IP Ref Number [REDACTED]

I would like to add to comments made on my initial representation concerning BMV

Ref RAC/9611/2A	Rev. B
Drawn by AGM	Checked by AIF
Scales 1:10,000@A3	Date 09/2025

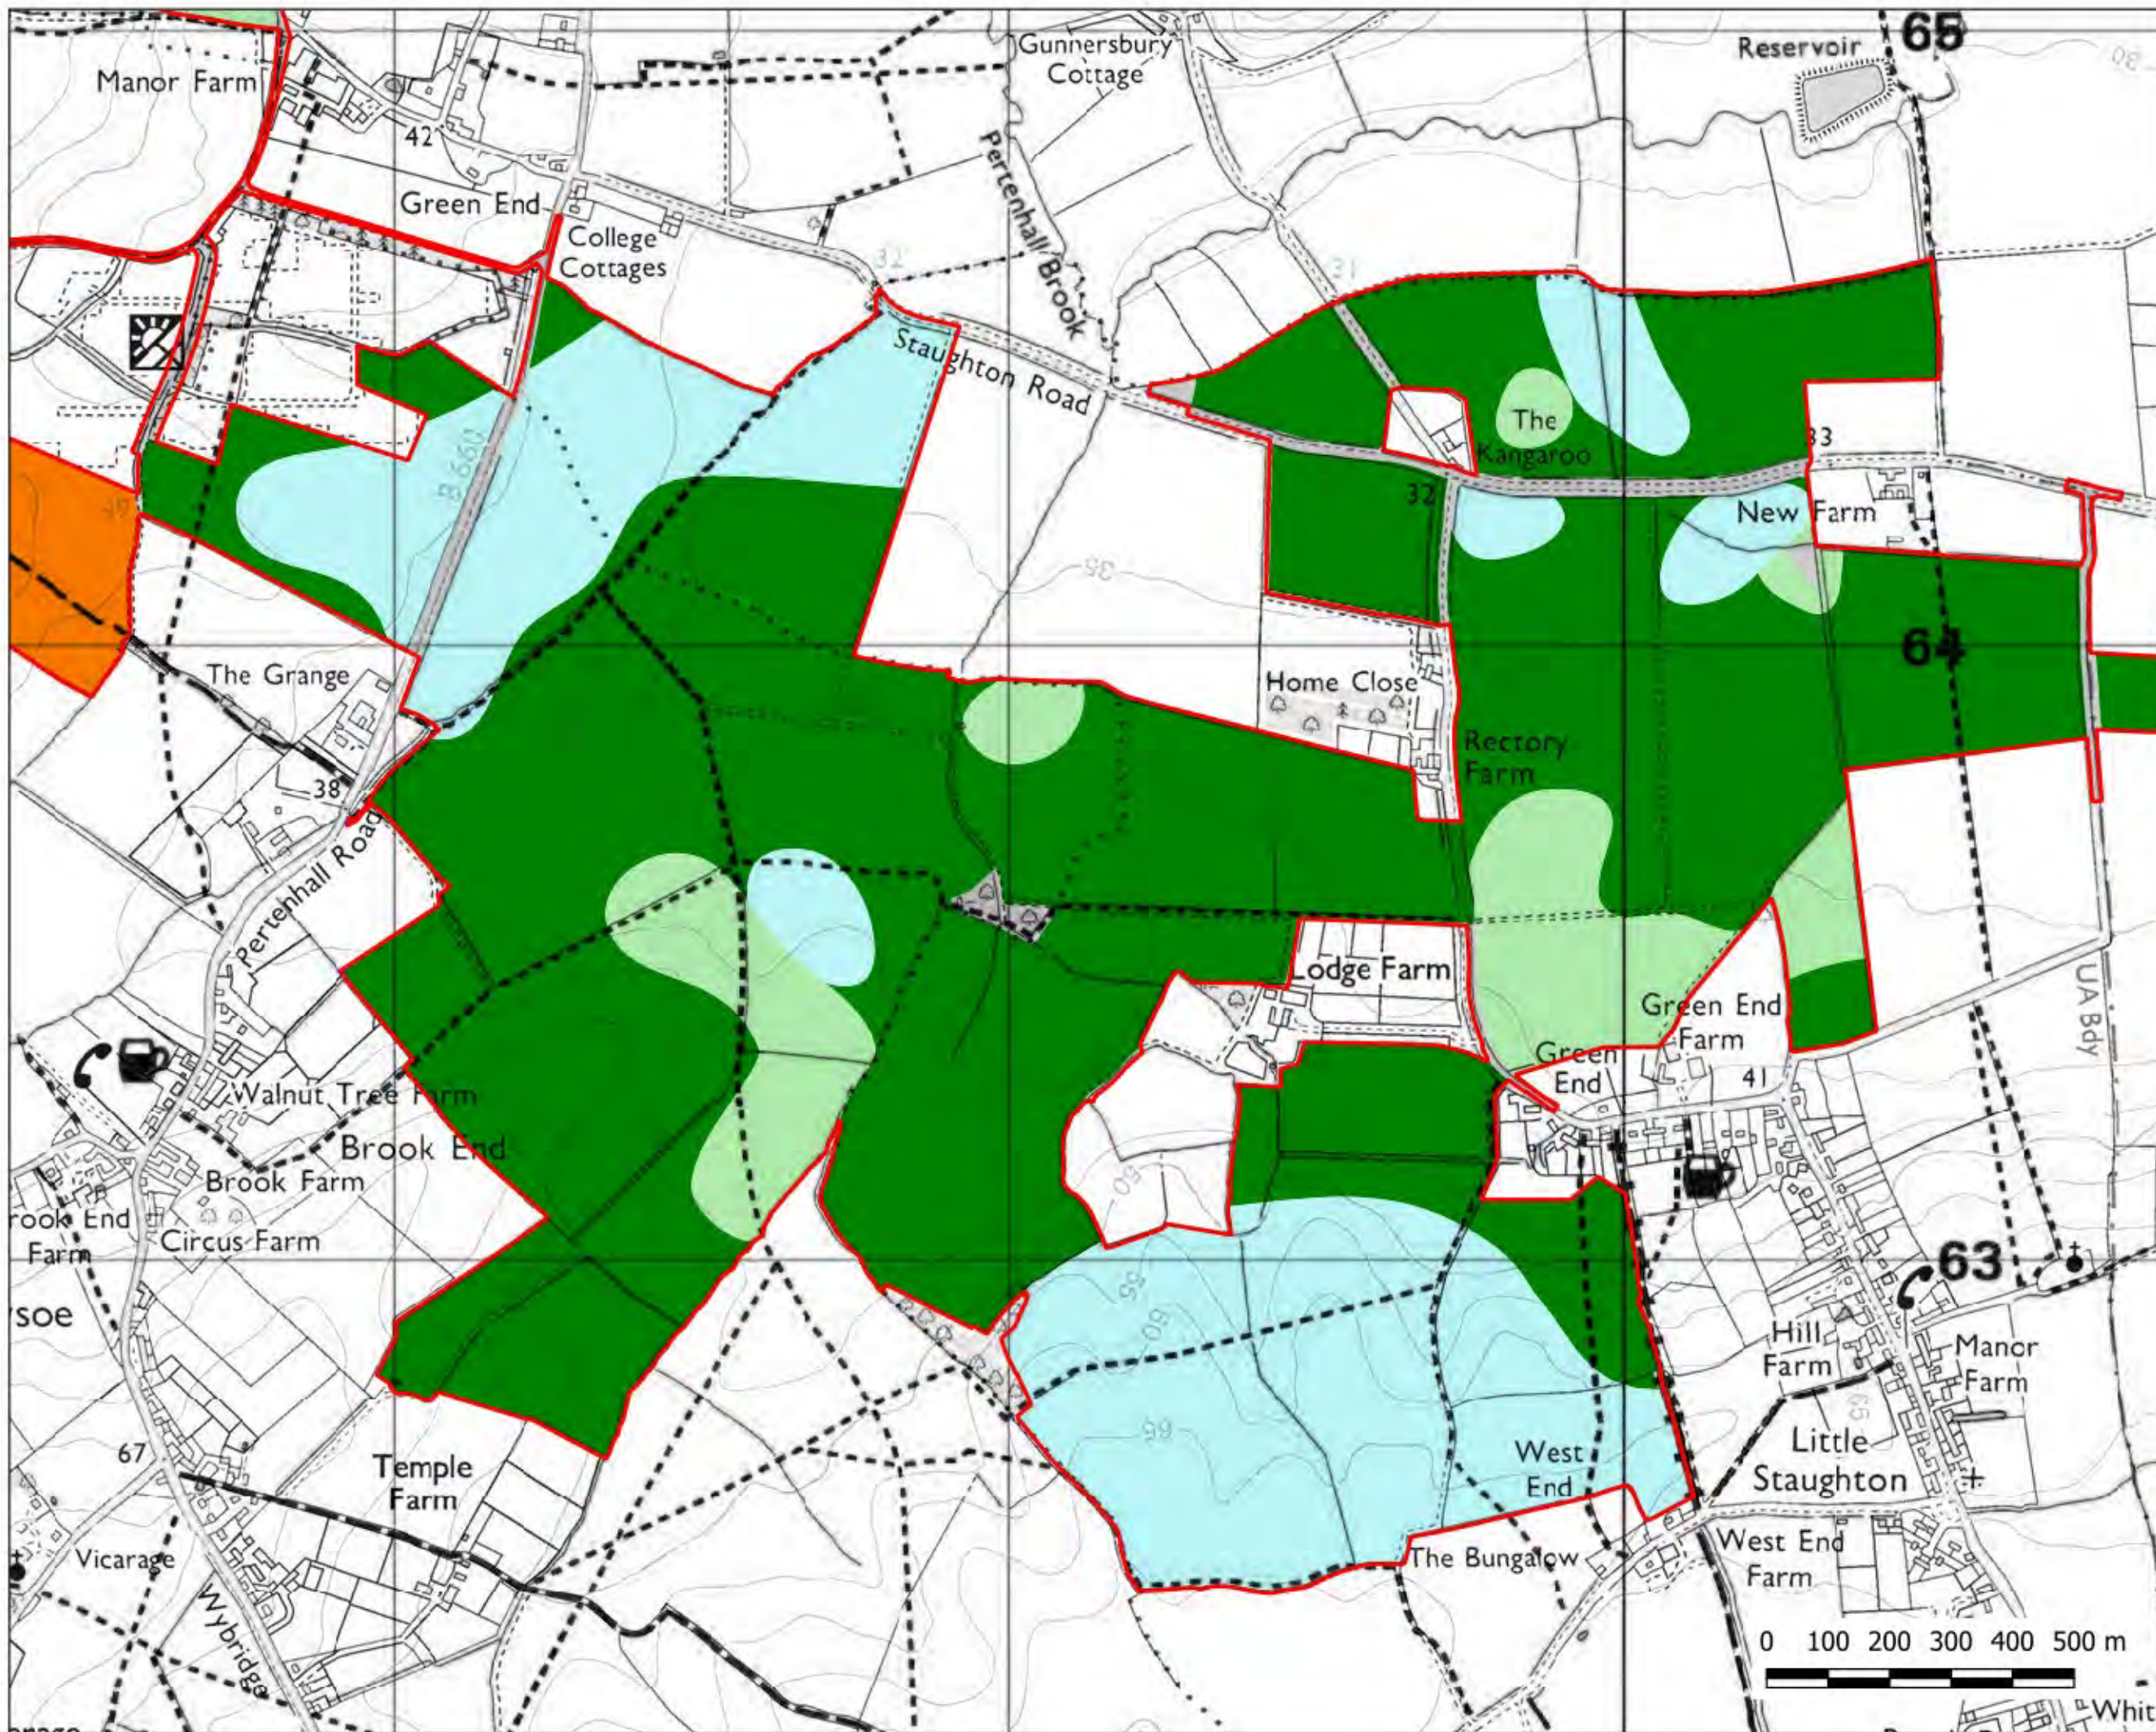
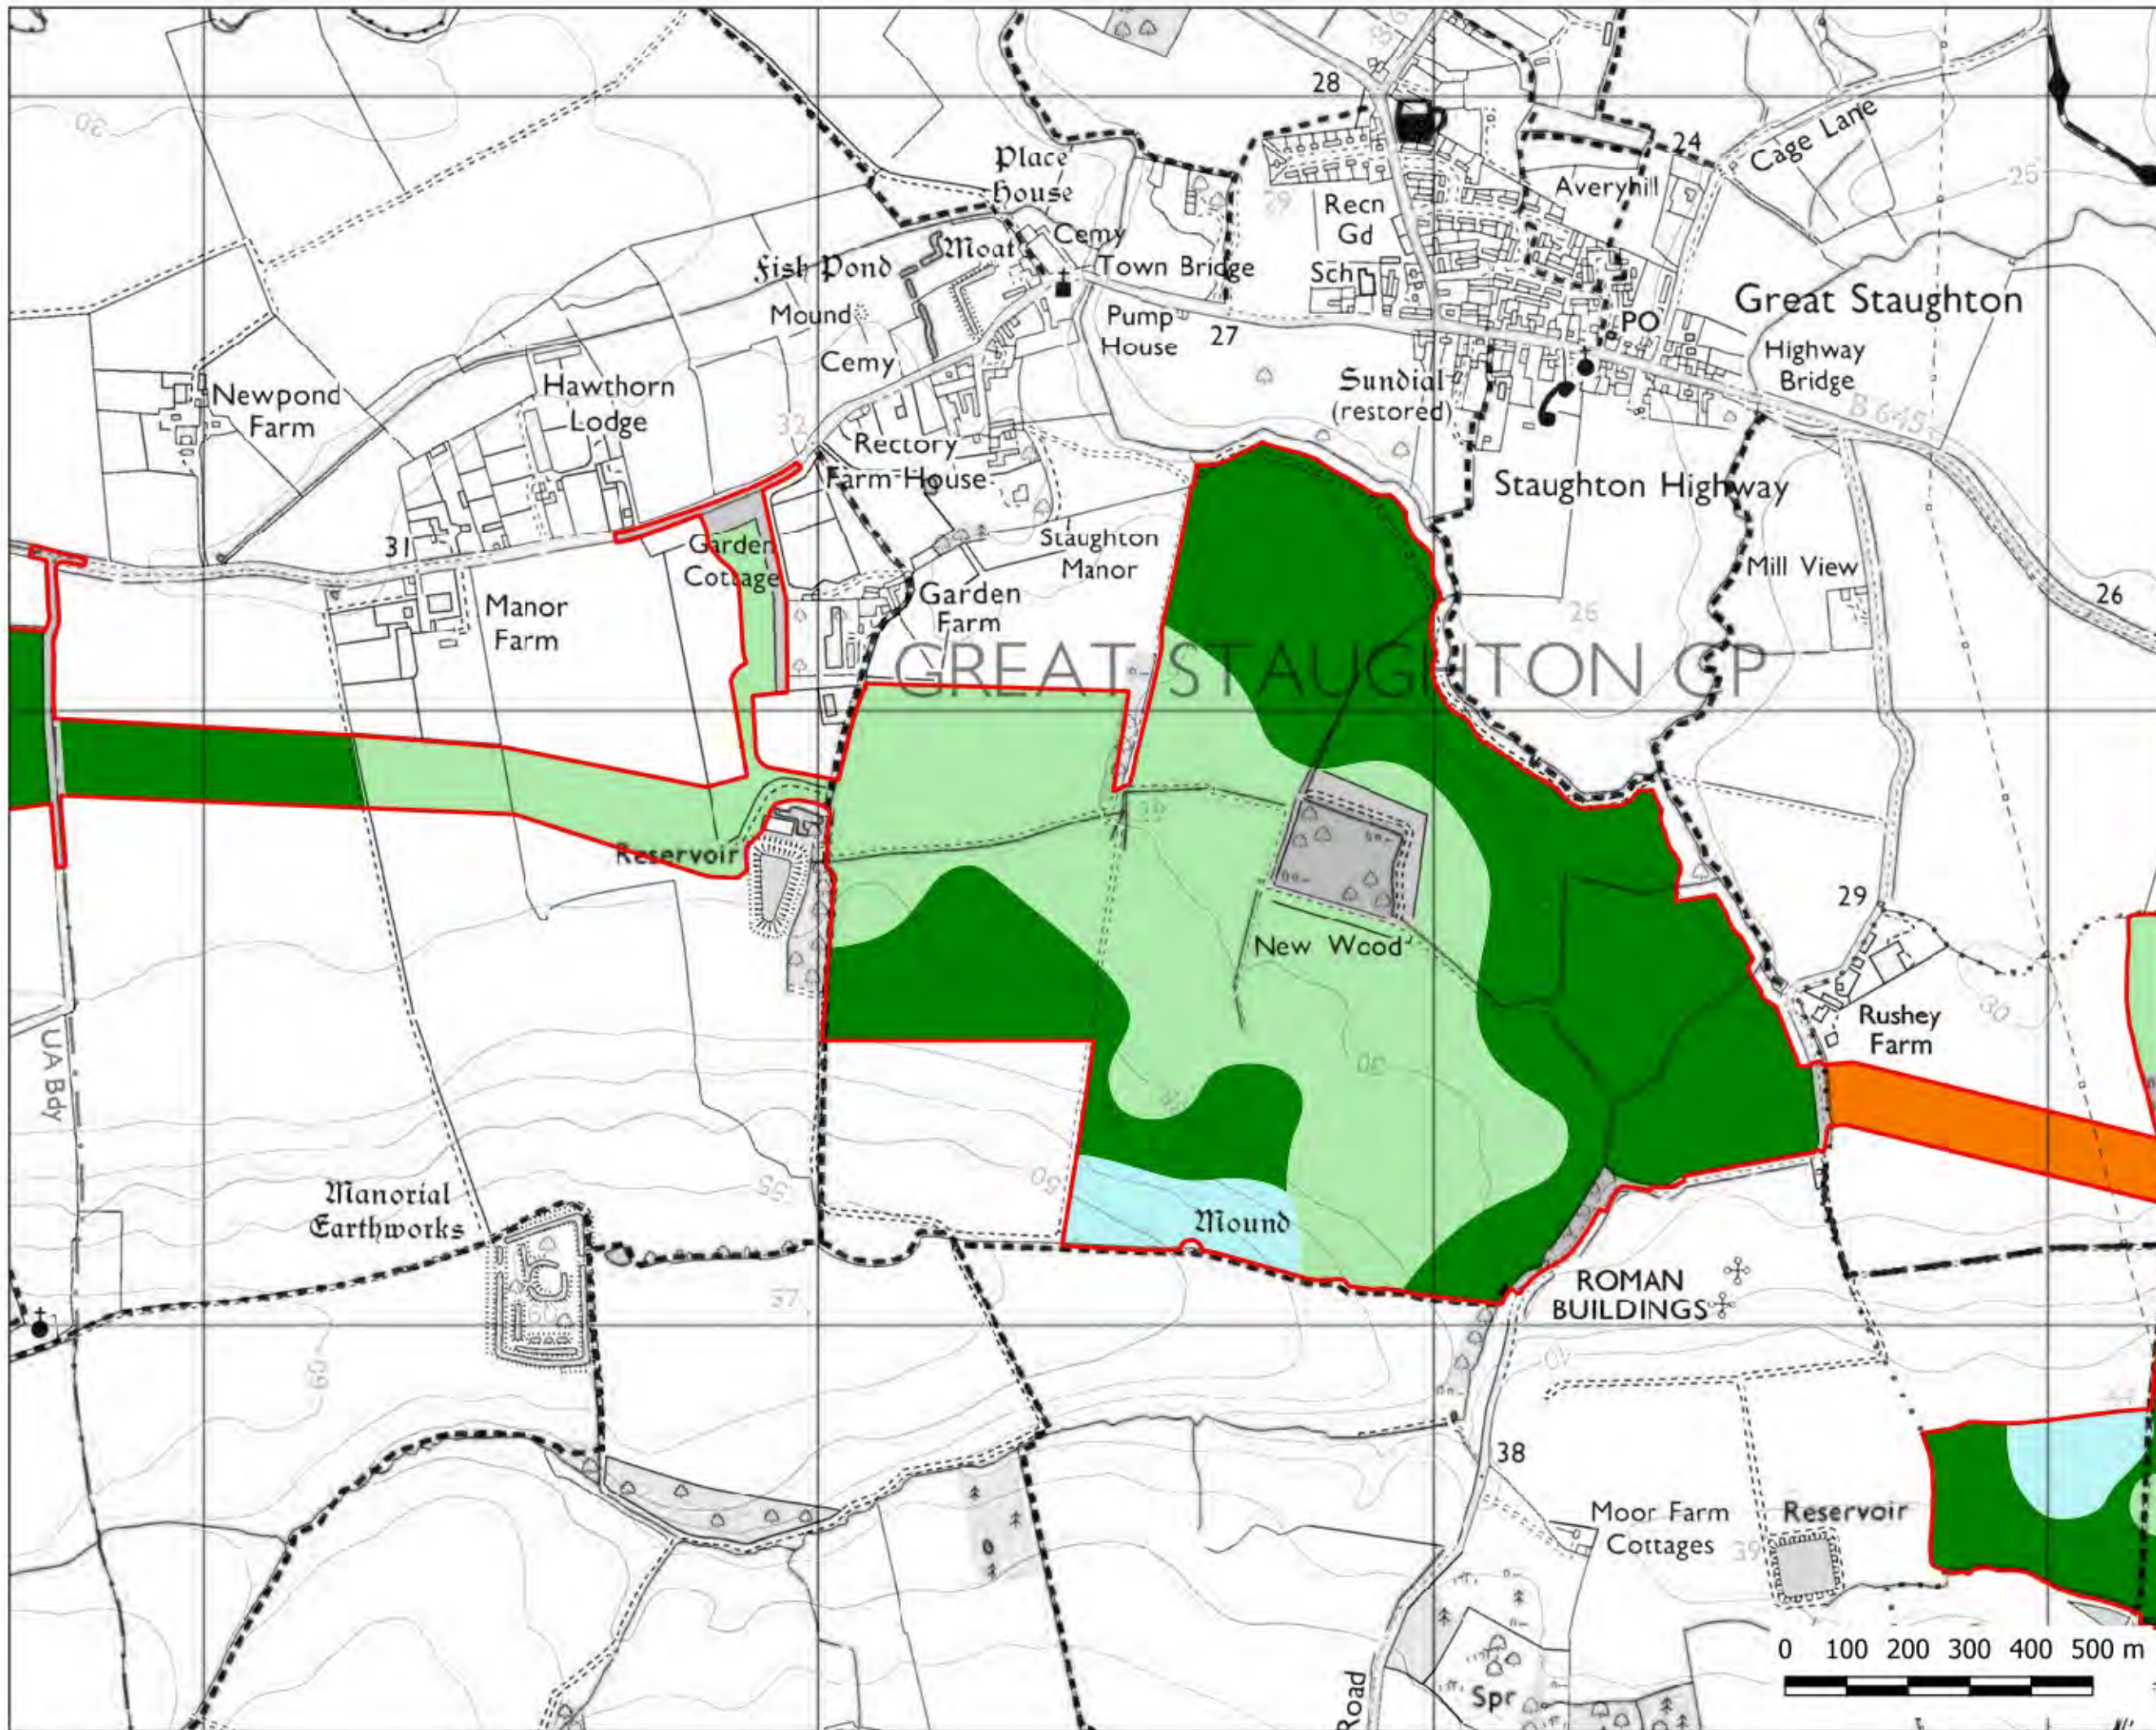
The level of BMV is critical to the planning application as government guidelines state that development should be avoided on these areas. In AP-049 Tables 13.8 /13.9 and 13.10 the applicant provides a summary of the land quality of the solar farm, as assessed by sampling, in comparison to the surrounding areas. Their conclusion is that the site is in "a part of the local area that is of comparatively lower agricultural value". For this conclusion they use provisional map data which they state "are not sufficiently accurate for use in assessment of individual fields or on development sites". Examination of the provisional maps for the site gives a value of Class 2 land as higher than 40%, much closer to the local average. In terms of yield, which can also be used to classify land, the applicant's average assessment of 8 tonnes per hectare would give a soil class of 3a.

During the assessment of BMV area the applicant includes non-agricultural land i.e. buildings, roads and trees of 4.6%(EPE). As these are areas not available for agriculture or panels, they should not be included in the BMV calculation. Removal would raise the level of BMV for the site.
